Our Ref: BN/116/19/HH

**Town & Country Planning Act 1990 (as amended)
Town & Country Planning (Development Management Procedure) (England) Order 2015
Application for Planning Permission for Works or Extension to a Dwelling**

Development Single storey rear extension and addition of a first floor

Location 19 Elm Grove Barnham

FOR MR & MRS HARVEY		
SITE 19 ELM GROVE, BARNHAM, WEST SUSSEX. PO22 0HJ		
TITLE PROPOSED EXTENSION & ALTERATIONS BLOCK PLAN		
SCALE 1: 500 © A3	DRAWN AH 09/19	DRAWING NO. 01B REV. A

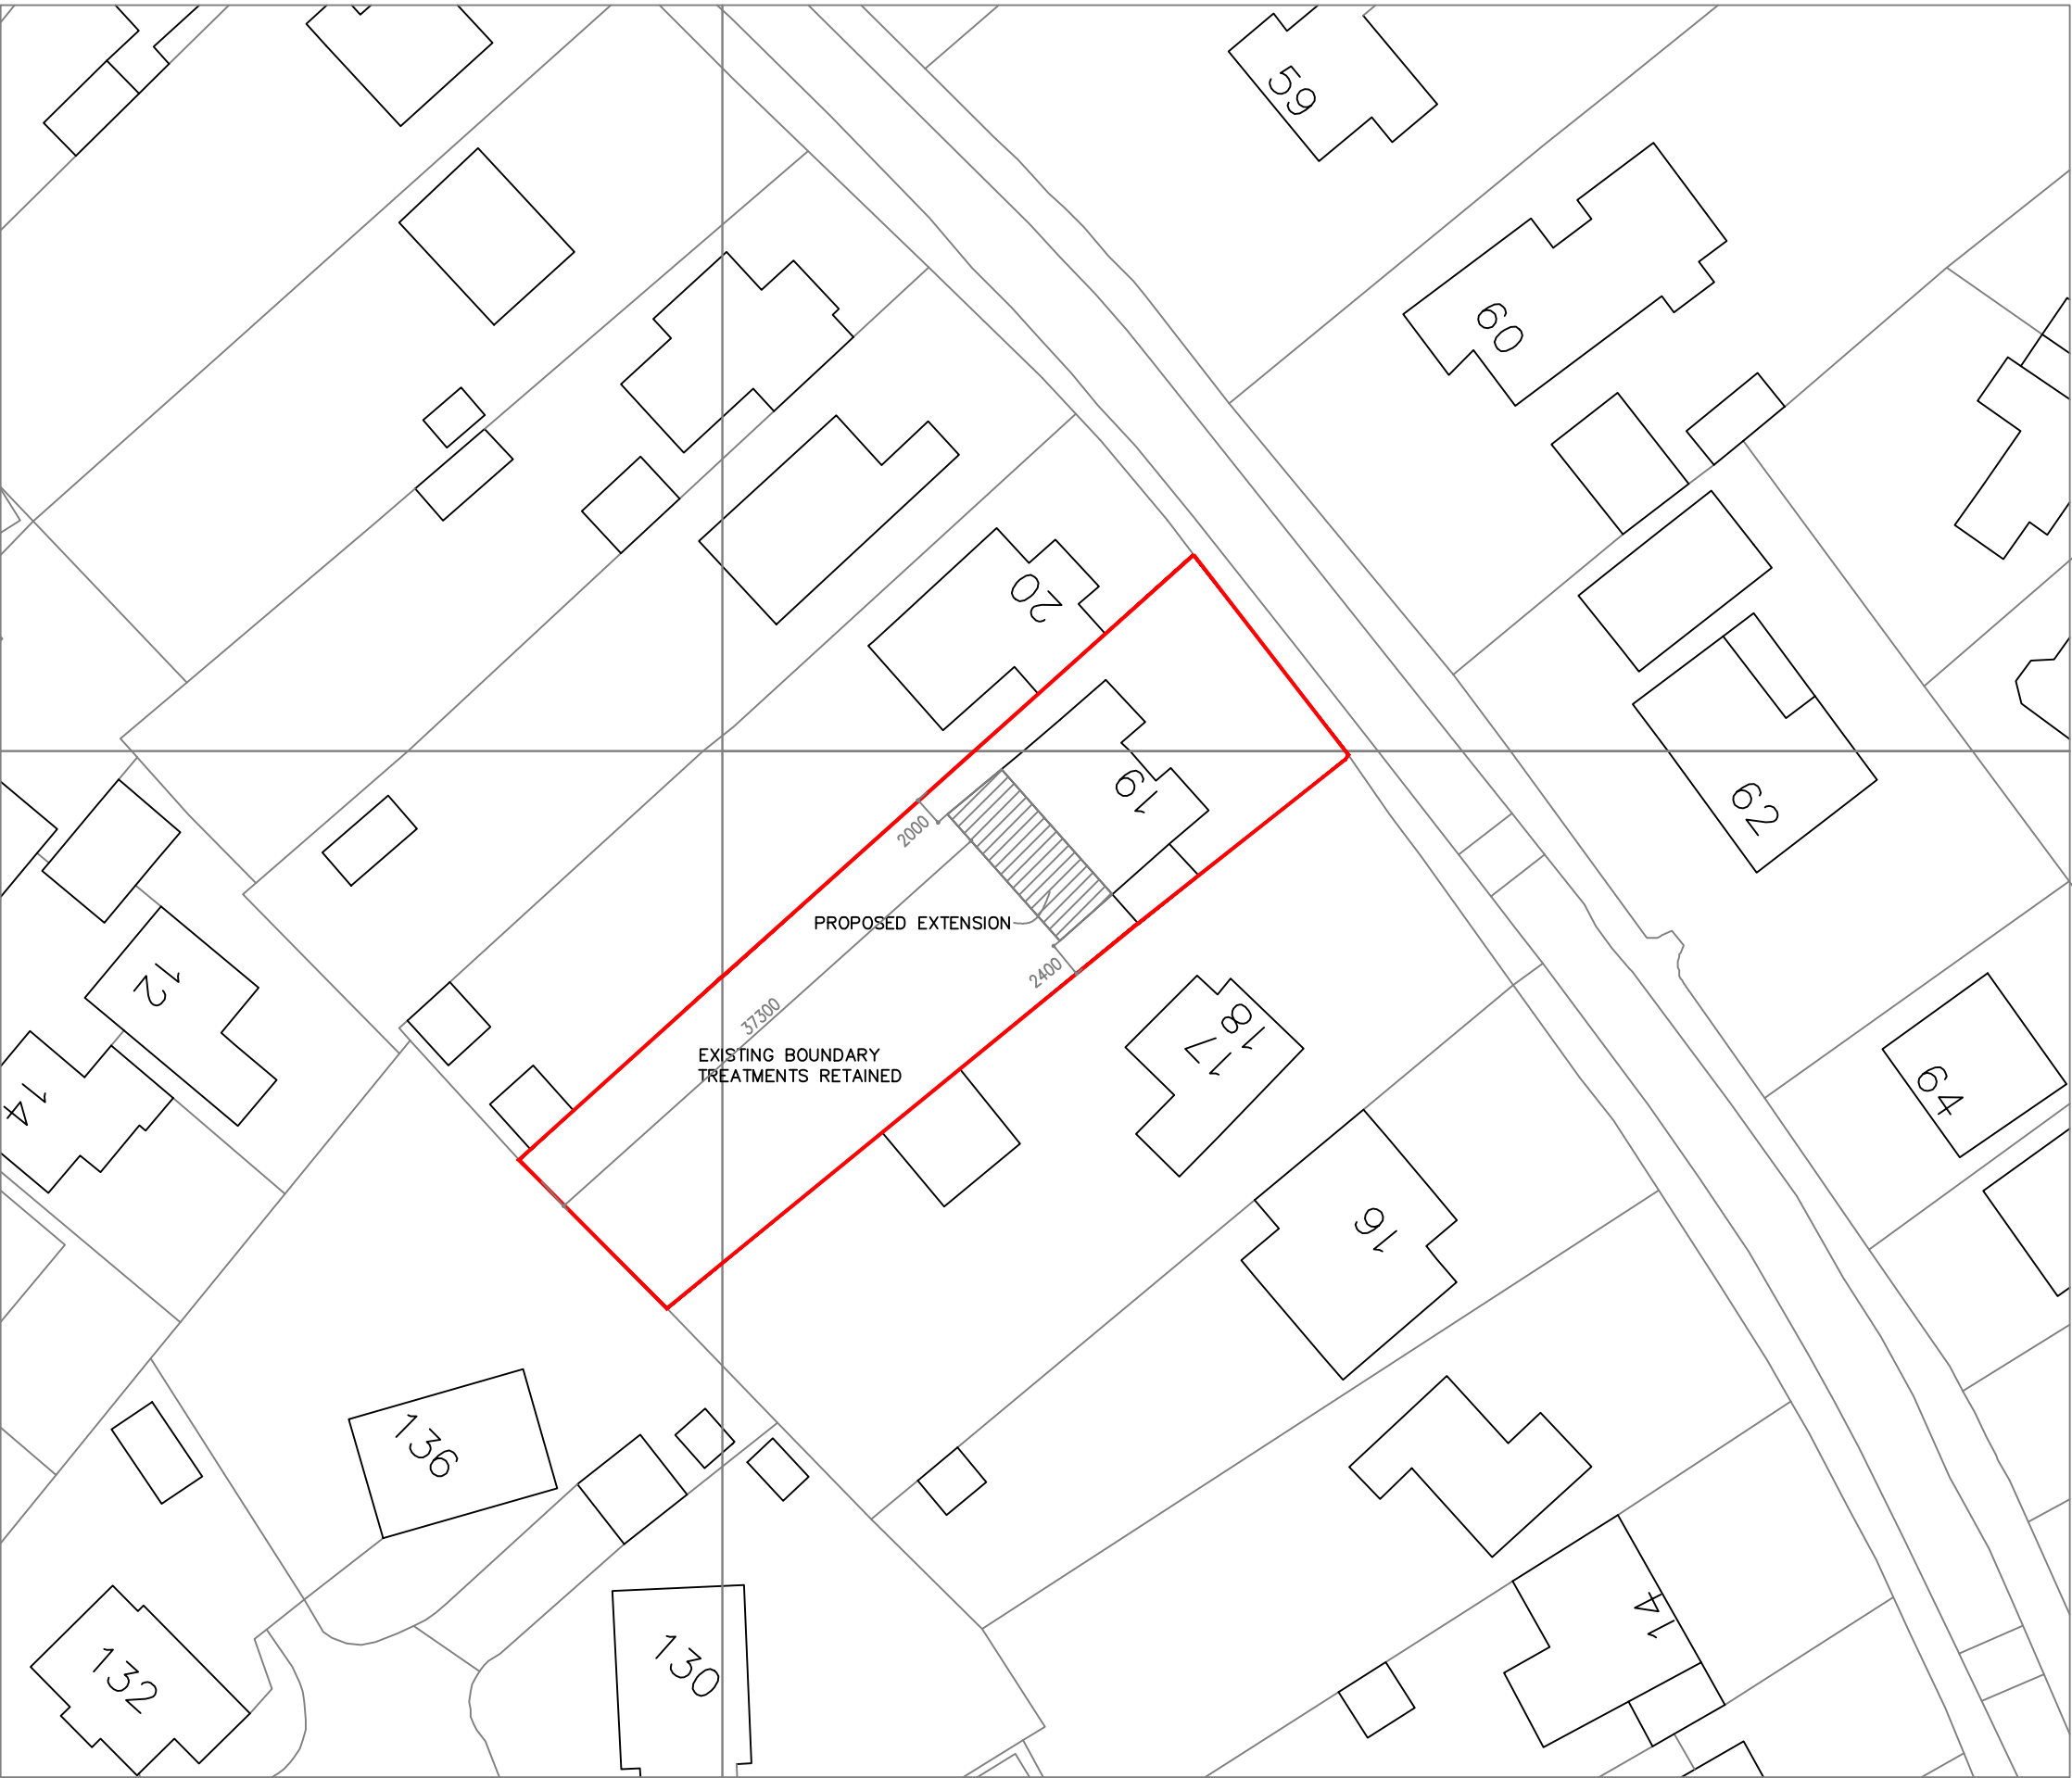
Block Plan

You are required to include dimensions from the proposed extensions to all site boundaries. Please amend.
